ENVIRONMENT PROTECTION AUTHORITY

**Hanson Concrete and Asphalt Facility Eastern Creek (CP 06_0025 MOD 1) Site Layout
Amendments – Submissions and Recommended Conditions**

The Environment Protection Authority ("EPA") has reviewed the modified concept plan dated 12 June 2012 prepared by Hanson Construction Materials Pty Ltd and based on the information set out in the modified concept plan, provides additional recommended Conditions of Approval for your consideration as Attachment A.

Attachment A
EPA – Additional Comments and Recommended Conditions of Approval
Hanson Concrete and Asphalt Facility Eastern Creek (CP 06 0025 MOD 1)

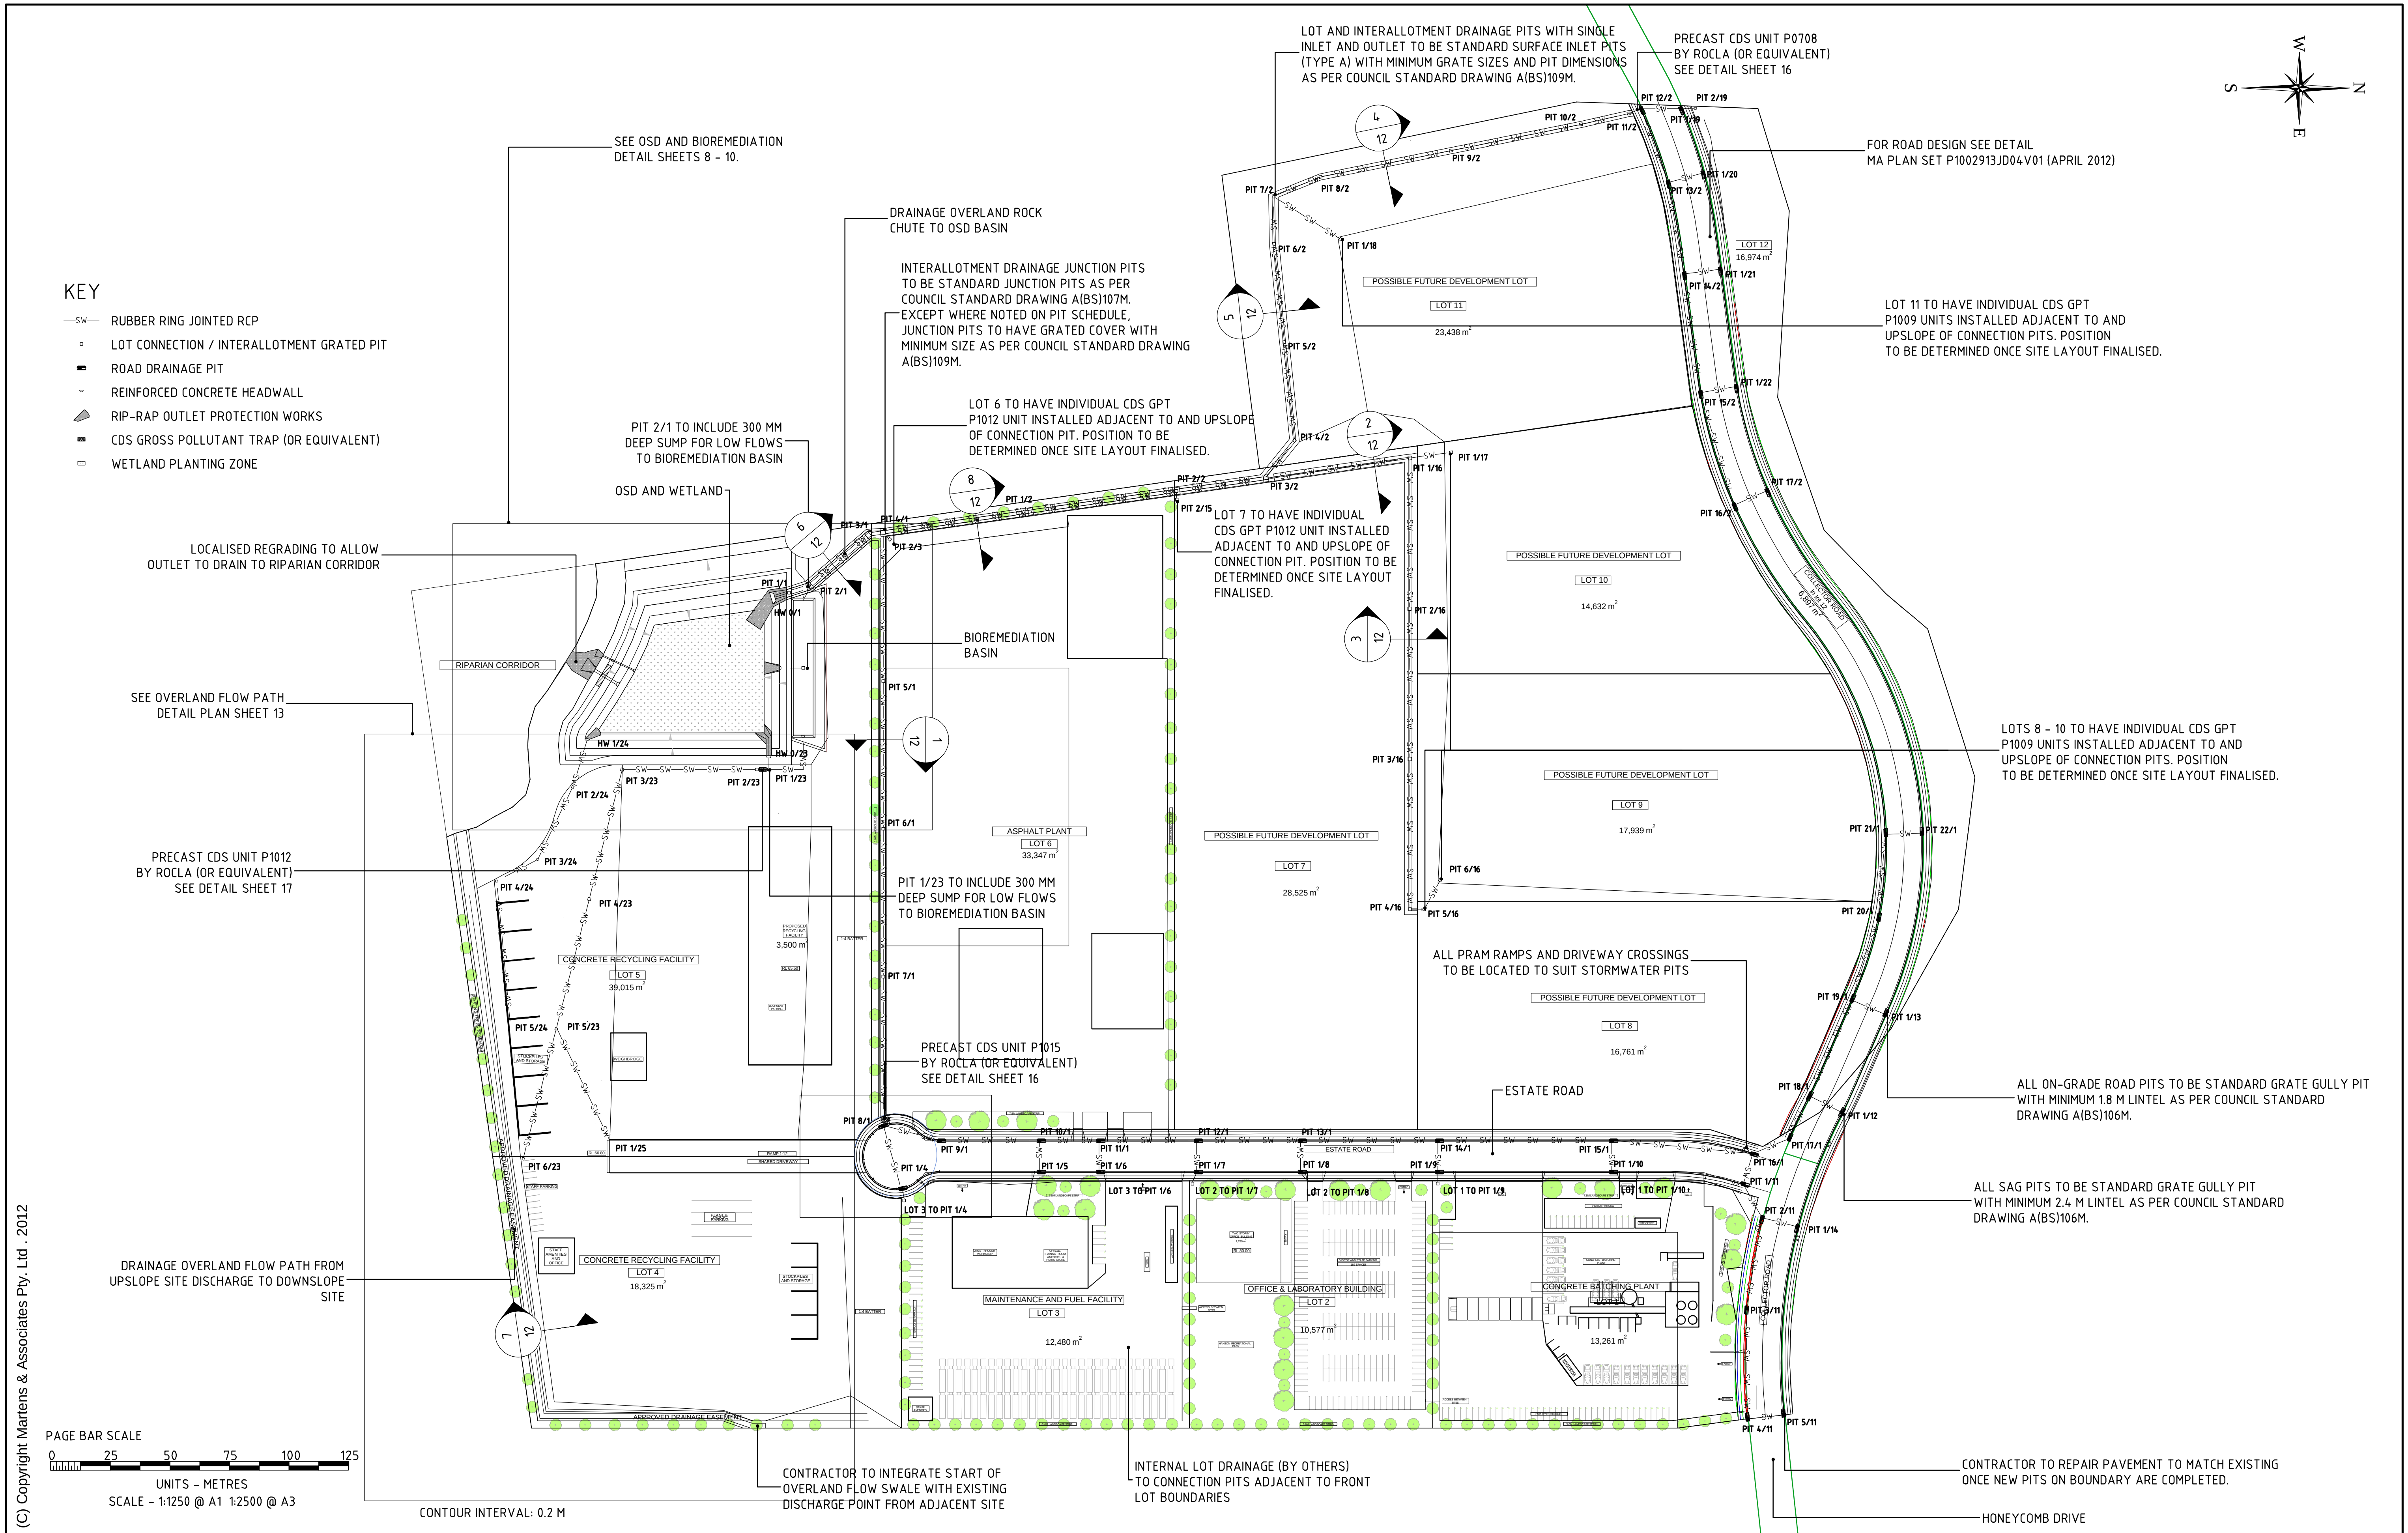
EPA's original comment to the EMS: *The Stormwater Management Scheme (Attachment C) does not address the possibility that areas of the Fulton Hogan Asphalt Plant may be subject to TPH/BTEX and chlorinated hydrocarbon contamination, or controls determining whether or not the surface water collected would be suitable for on site reuse. The Stormwater Management Scheme must consider the appropriateness of reusing the collected stormwater from the Fulton Hogan Asphalt Plant.*

EPA considers this response inadequate as EPA has received recent contamination reports for the Fulton Hogan asphalt plant suggesting the potential for TPH/BTEX and chlorinated hydrocarbon

contamination. While the report states that the site is considered suitable for continued industrial use, there is no assessment of the suitability of the onsite water for irrigation.

EPA recommends that prior to the reuse of any onsite water originating from the asphalt plant site, an EPA auditor review the contamination assessments, and if required, develop a sampling and analysis program to determine the suitability of the onsite water for irrigation.
